Rampion Two Offshore Wind Farm

Appendix J5 to the Natural England Deadline 5 Submission

Natural England's Advice on Terrestrial Ecology

09 July 2024

- **Graphic A-2:** Indicative illustration of vegetation notched to 6m and showing new planting;
- **Graphic A-3:** Indicative illustration of vegetation notched to 14m and showing new planting; and
- **Graphic A-4:** Indicative illustration of vegetation cleared to 20m and showing new planting.

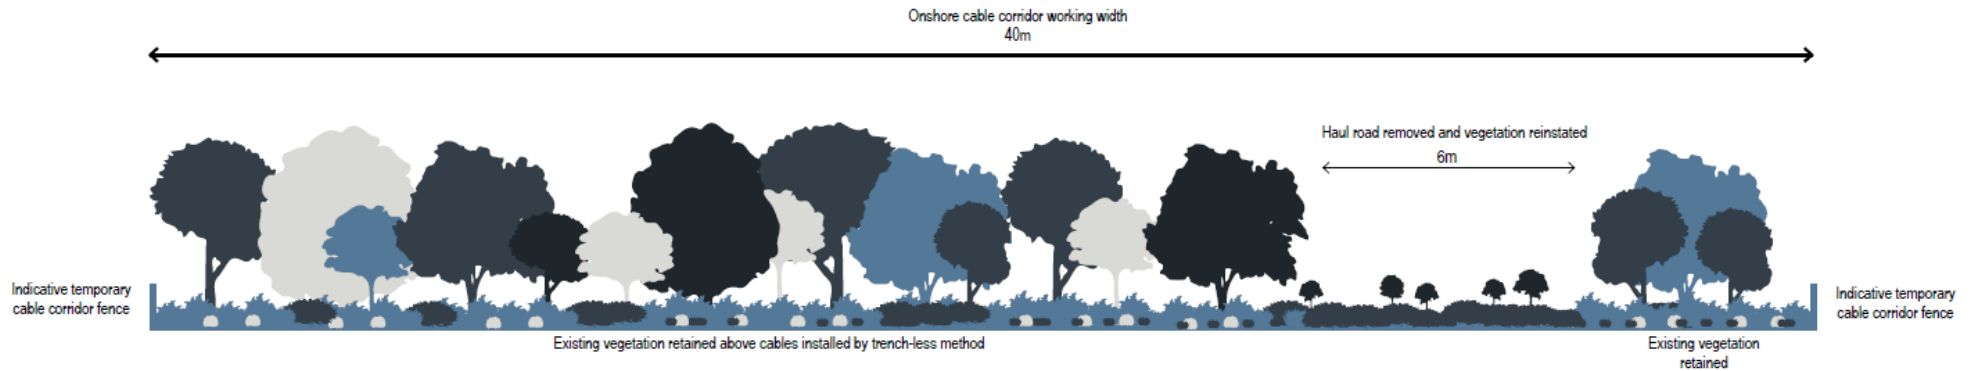
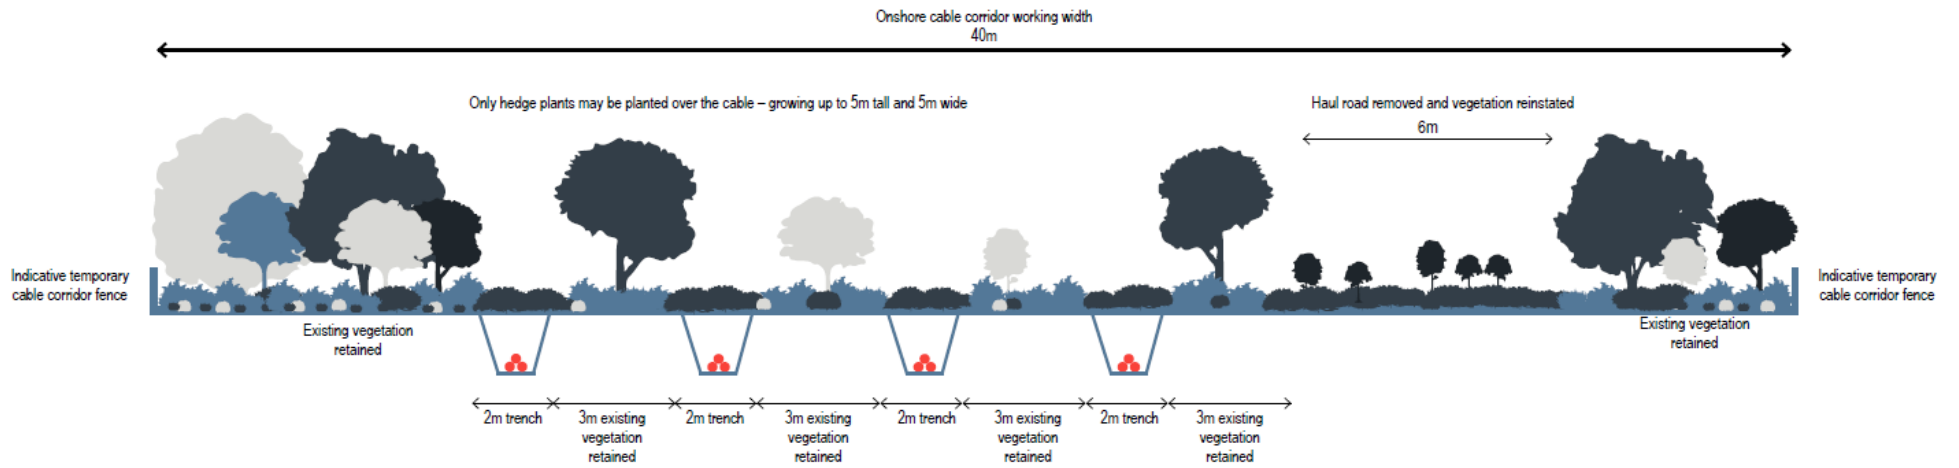
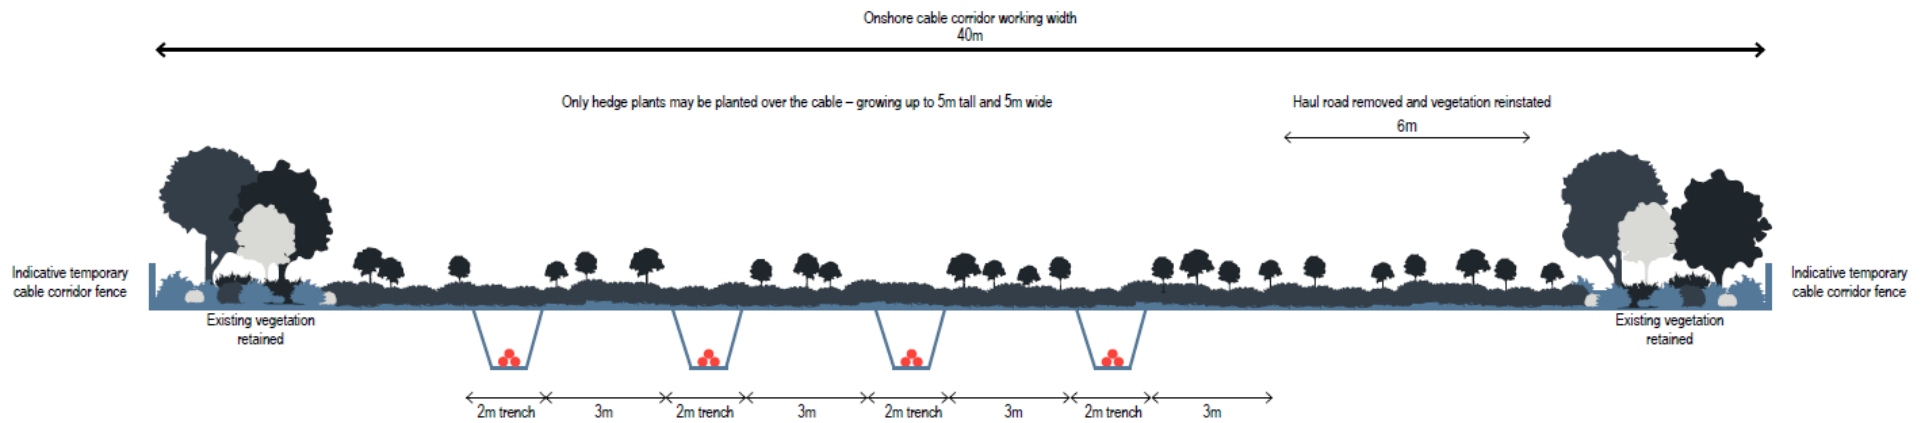
Point number	Location within Submitted Document			Natural England Response	
	Section	Page	Paragraph, Table or Figure Number	Key Concern	Natural England's Advice to resolve the issue
3	22.7	122	Table 22-20	<p>Commitment C-115 states that <i>'Hedgerows/tree lines crossed by the cable route will be 'notched' to reduce habitat loss and landscape and heritage impacts wherever possible. This is defined as removing one or more short sections (notches) within the same hedgerow/tree line. The removed sections will by default be replanted except where permanently lost on the Vegetation Retention Plan (see Appendix B – Vegetation Retention Plans in the Outline Code of Construction Practice). Where appropriate, hedgerows will be temporarily translocated to maintain diversity and structure and result in more rapid reinstatement. Hedgerow/tree line losses will be kept to approximately 14m total width at each hedgerow crossing point where notching can take place. For Hedgerows deemed "important" under the Hedgerows Regulations 1997 (or where there are other considerations), losses will be reduced to a 6m notch for the temporary construction haul roads only, by trenchless installation of the cable ducts under them wherever possible (see Appendix B - Vegetation Retention Plans in the Outline Code of Construction Practice for the extent of hedgerow losses at each location).</i></p>	<p>Natural England welcomes the amendments in relation to terrestrial ecology and have no further comments. Please note that comments pertaining to landscape and visual impacts will be provided in our Deadline 6 response.</p>

Point number	Location within Submitted Document			Natural England Response	
	Section	Page	Paragraph, Table or Figure Number	Key Concern	Natural England's Advice to resolve the issue
				<p><i>Hedgerows subject to temporarily translocation will be lifted using a tree spade to maintain diversity and structure and result in more rapid reinstatement. Where chances of success are questionable, notches will be made by removal and reinstatement through planting. The ECoW will justify the approach being taken in line with the responsibilities of implementing the vegetation retention plan (see C-220).</i></p> <p><i>Reinstated hedgerows and tree lines will be monitored over a period of 10 years, and remedial action taken rapidly where signs of failure are identified.</i></p> <p><i>Further details are provided in the outline Code of Construction Practice and outline Landscape and Ecology Management Plan.'</i></p>
